DRB CASE ACTION LOG

DRB Application No.: 04DRB-00181 (ASBP)

Project Name: VOLCANO BUS PARK PHASE 2

CITY OF ALBUQUERQUE
PLANNING DEPARTMENT
Development Review Board
2/18/04 Comments

| SHEET: C-1.1 |

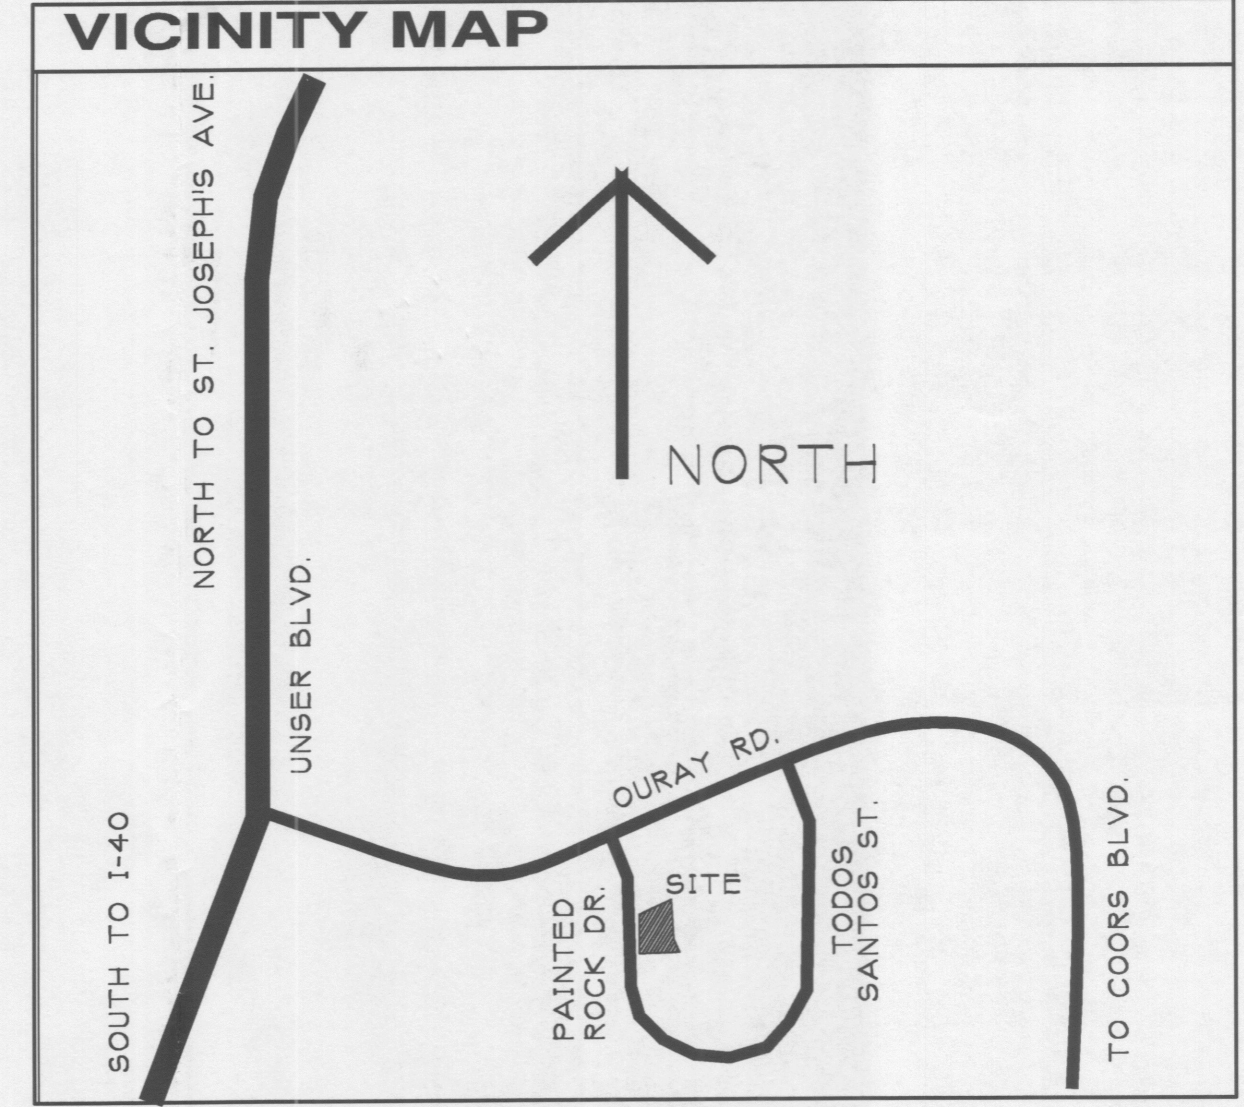
No.	Comment
✓ ①	KEYWAY @ END OF PARKING AISLE NEEDS TO BE 5' MINIMUM DONE
✓ ②	LADDER BUMPERS DONE
✓ ③	IS THERE BE A RAMP REQ'D FROM VAN STALL ONTO SIDEWALK? - SIDEWALK ASPHALT TRANSITION IS FLUSH, NOW LACKED ON SITE PLAN
✓ ④	IS INFRASTRUCTURE IN PLACE ON PAINTED ROCK DRIVE? YES
✓ ⑤	ARE THERE ANY OFFSITE MITIGATION MEASURES? NO

- ✓ The Site Plan sheet with the signature block should be titled "Site Development Plan for Building Permit". **DONE**
- ✓ Is there existing development on the adjacent lots? If so, what is there? **-SEE PHOTOS**

- ✓ The property lines should be bold & easy to read on the plan. They are not clear. Only two are even labeled & even then, it is not clear where the line is. They should be bolder on the Landscape Plan as well. **2ND SIGN IS FUTURE TENANT**

- ✓ **Parking:** Spaces are not individually numbered as required. The handicapped space appears to be some distance from the main entrance to the building. **BLDG HAS 2 TENANTS**

SHEET TITLE:
LANDSCAPE PLAN

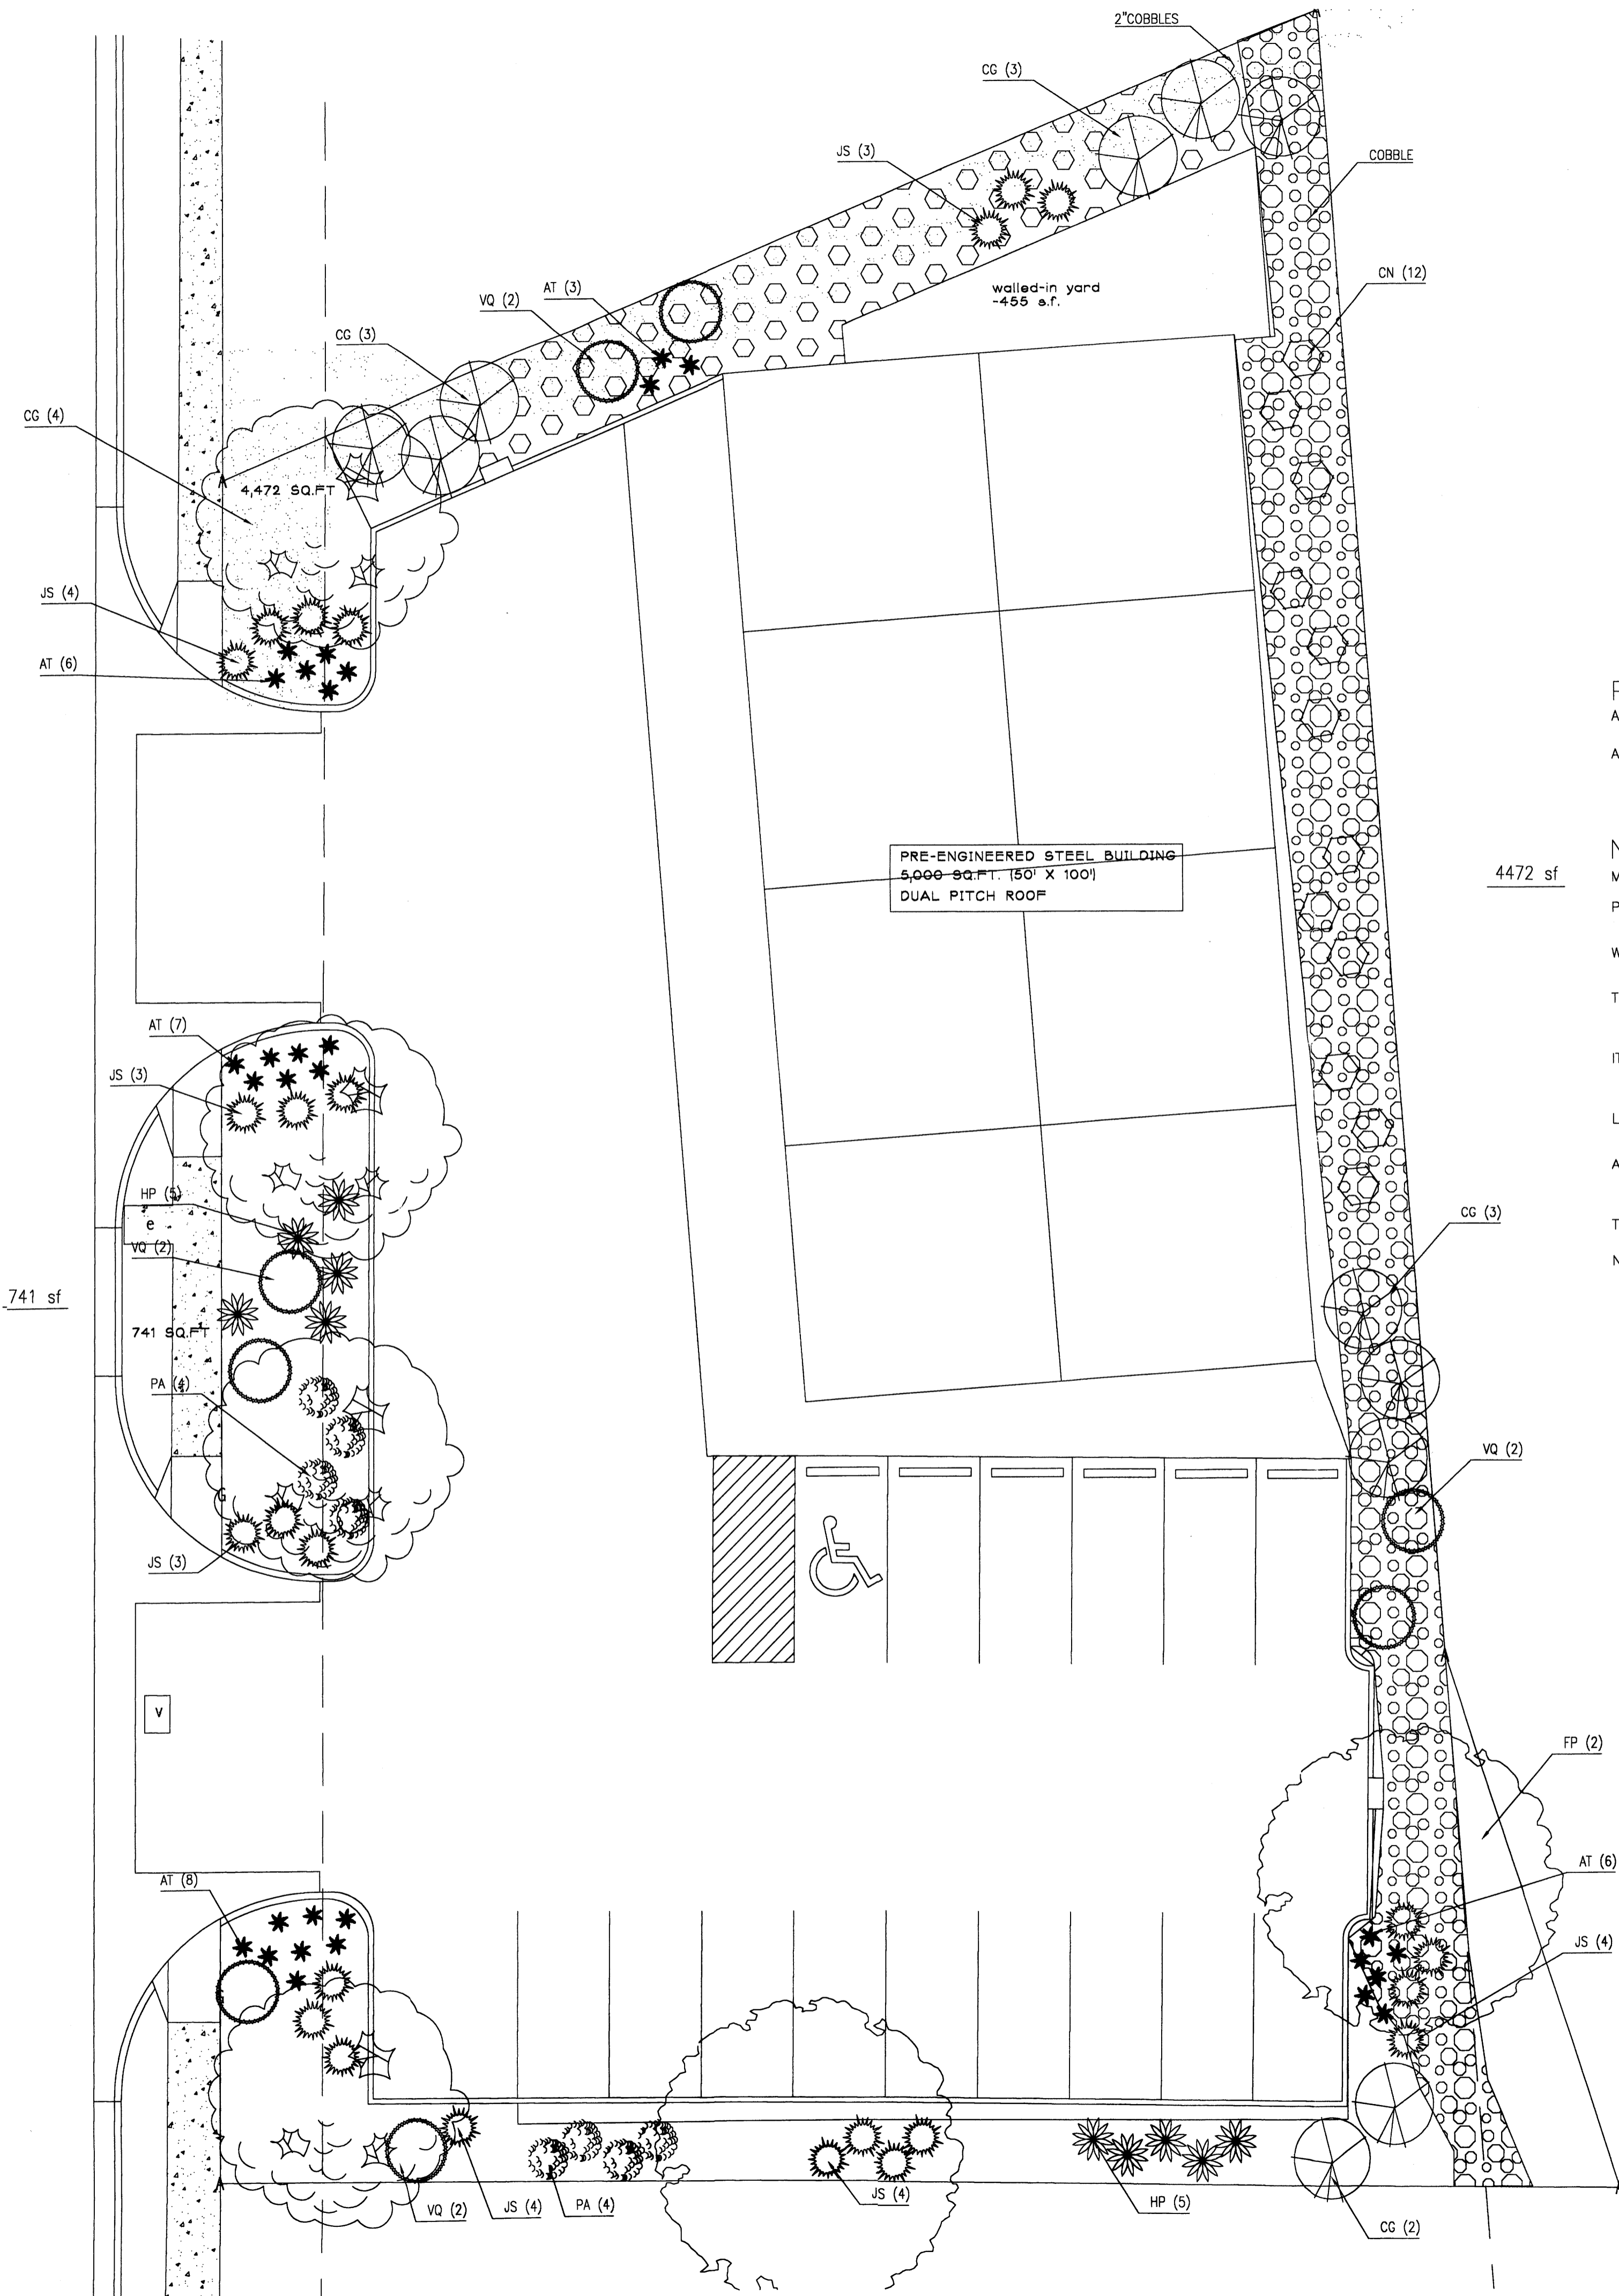
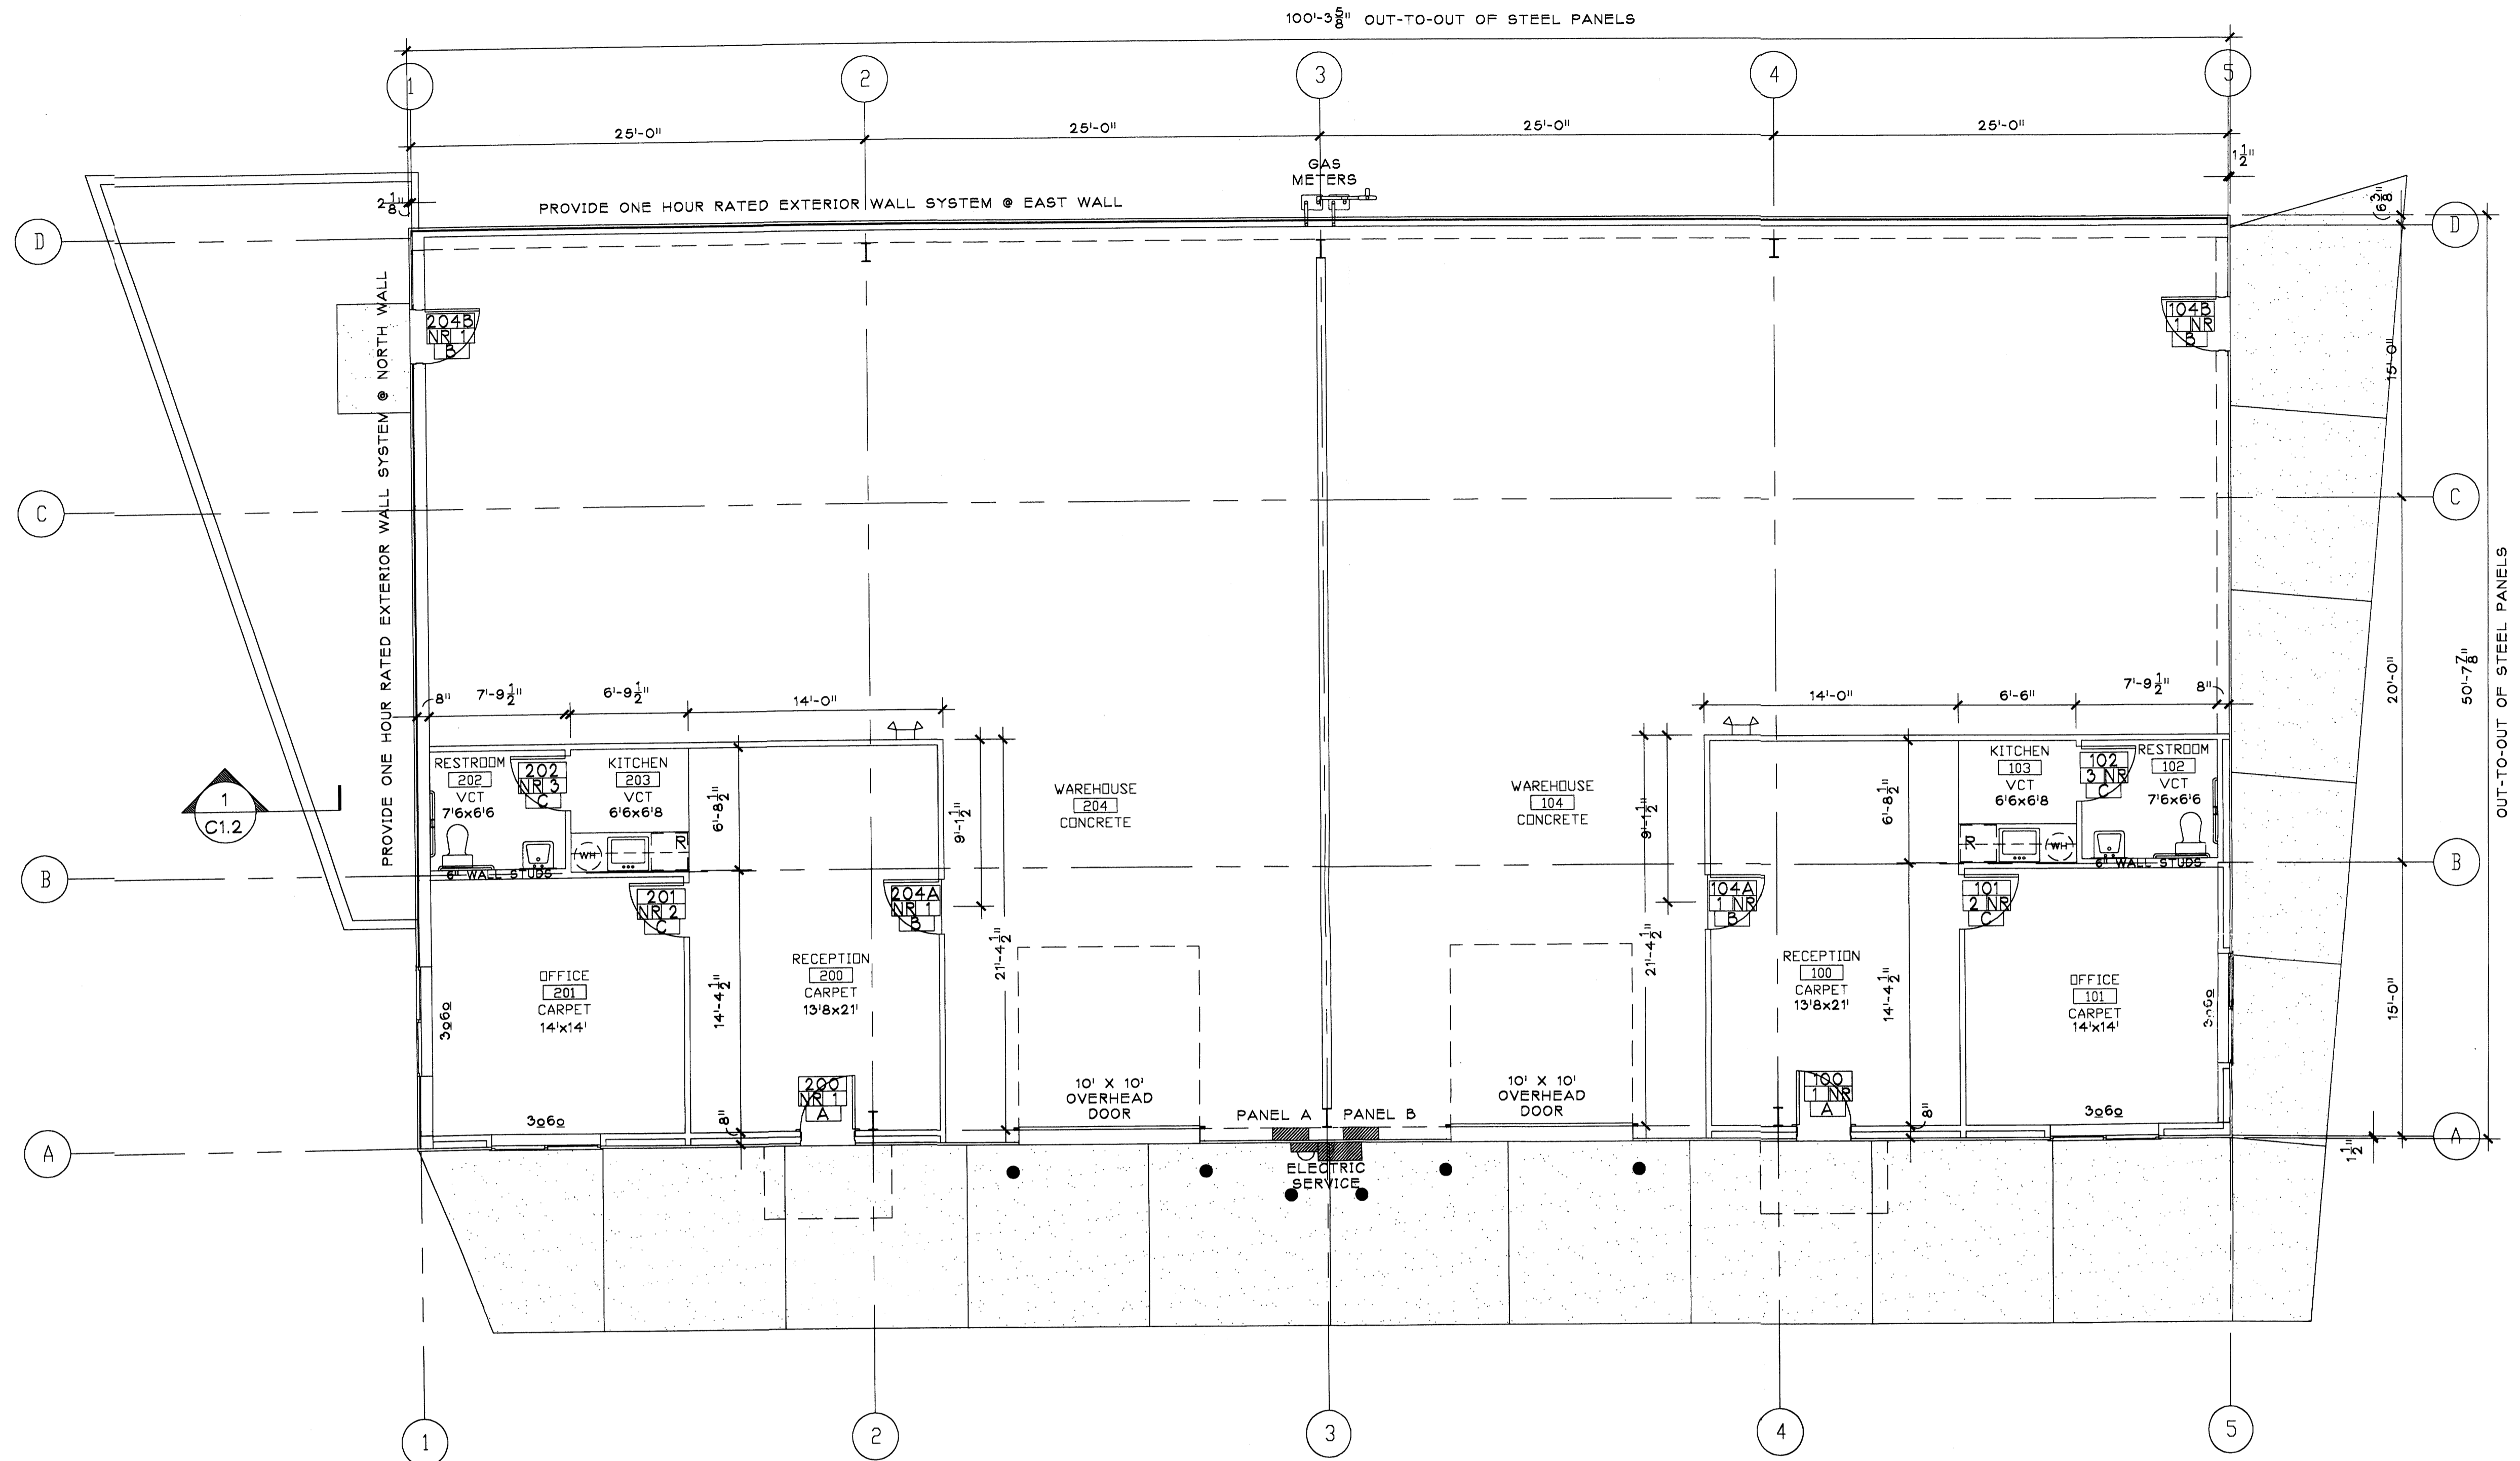
- ✓ **Landscape Plan:** Juniper is not an acceptable shrub. Please provide a substitute. The ash tree listed is a high water use tree according to the City Plant List. Please provide a lower water use substitute. **DONE**

- ✓ On the Landscape Plan sheet, please add 30% to Provided Landscape Area in the boxed notes.
- ✓ The Volcano Park Master Plan requires the planting of street trees along Painter Rock Drive which this property fronts. Although these trees are supposed to be planted between the curb & the sidewalk, the location shown immediately behind the sidewalk is acceptable provided the required 3" caliper tree is used instead of the 2" as indicated on the Plan. **DONE**

- ✓ It is unclear what the geometric symbols mean in the landscaping areas on the east & north sides of the property. **2'-4" COBBLES**

4 WEST ELEVATION
SCALE: 1/8" = 1' - 0"

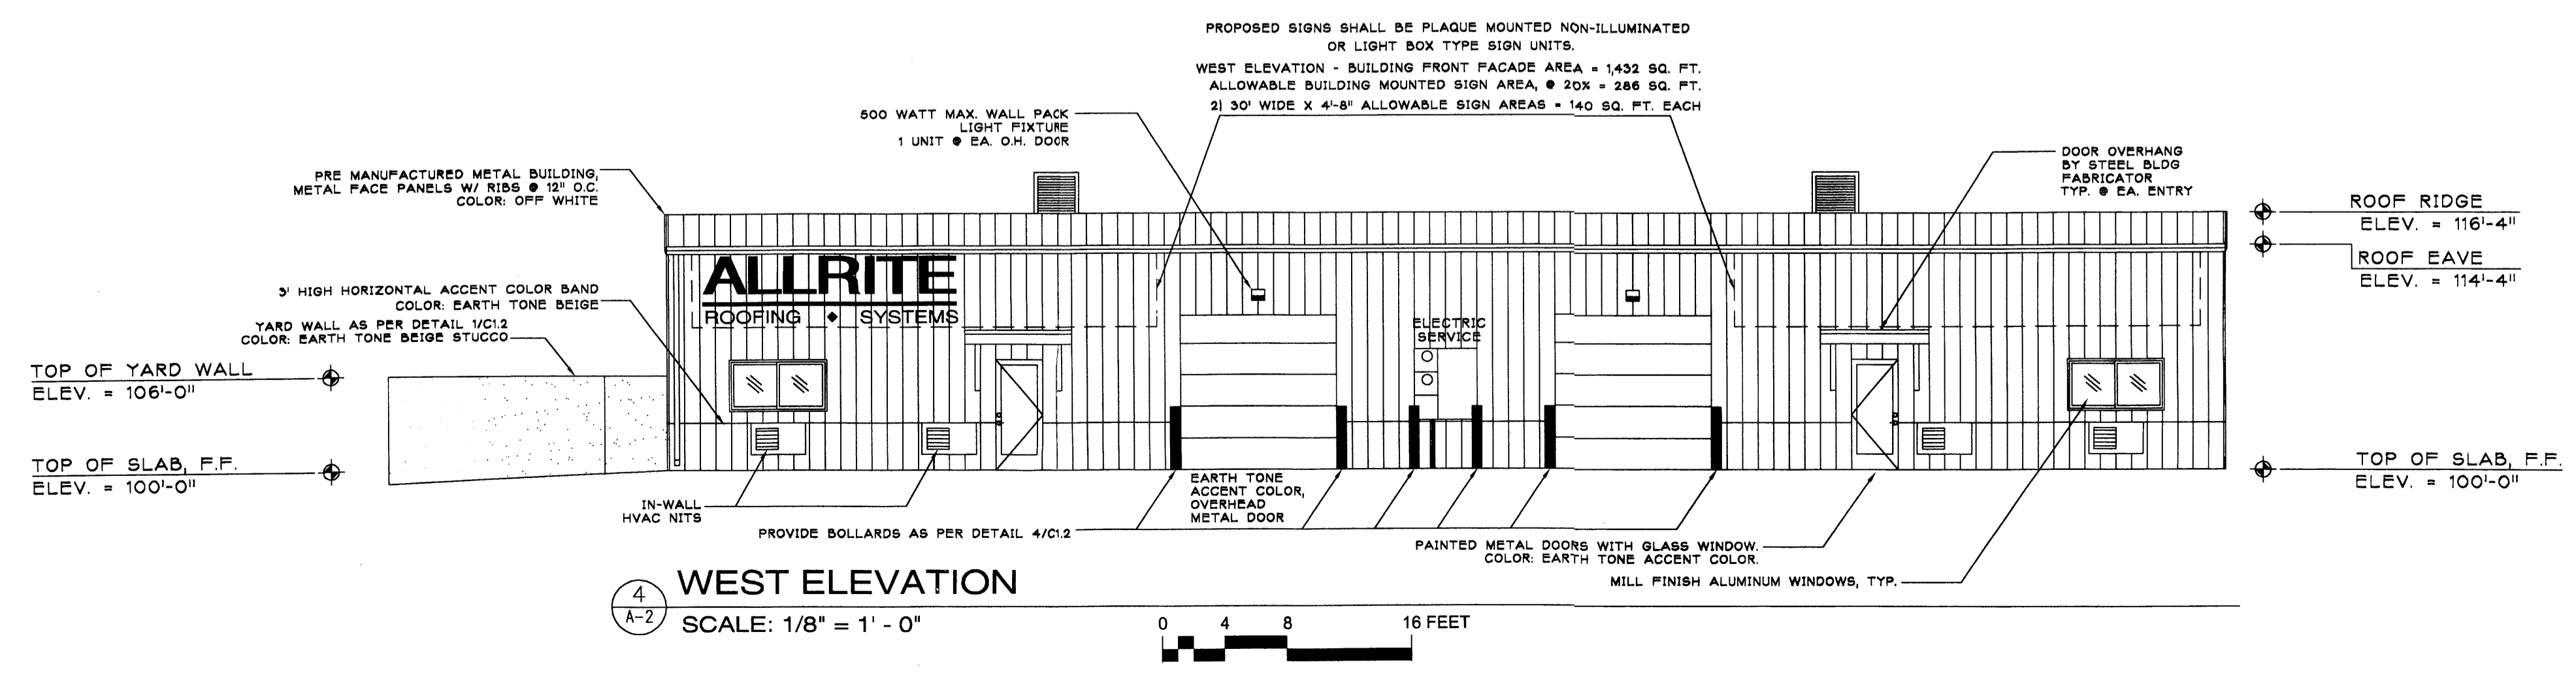
- ✓ Is the only sign the one shown mounted on the building? **- 2ND SIGN AREA LIMITS ARE ON WEST ELEVATION**
- ✓ Loading facilities are not identified as such on the site plan even though the wide doors are shown on the west elevation of the building. What size trucks are planned to use this area? **PANEL TRUCKS, NO SEMIS**

✓
Wall Mounted Sign: The dimensions are needed on the Elevations Sheet. This sign shall not exceed 20% of the area of the façade to which applied if sign is wholly visible from abutting collector street. Section 14-16-2-19 of Zone Code.

WALL SIGN SIZE LIMITS ARE ILLUSTRATED & NOTED ON WEST ELEV.
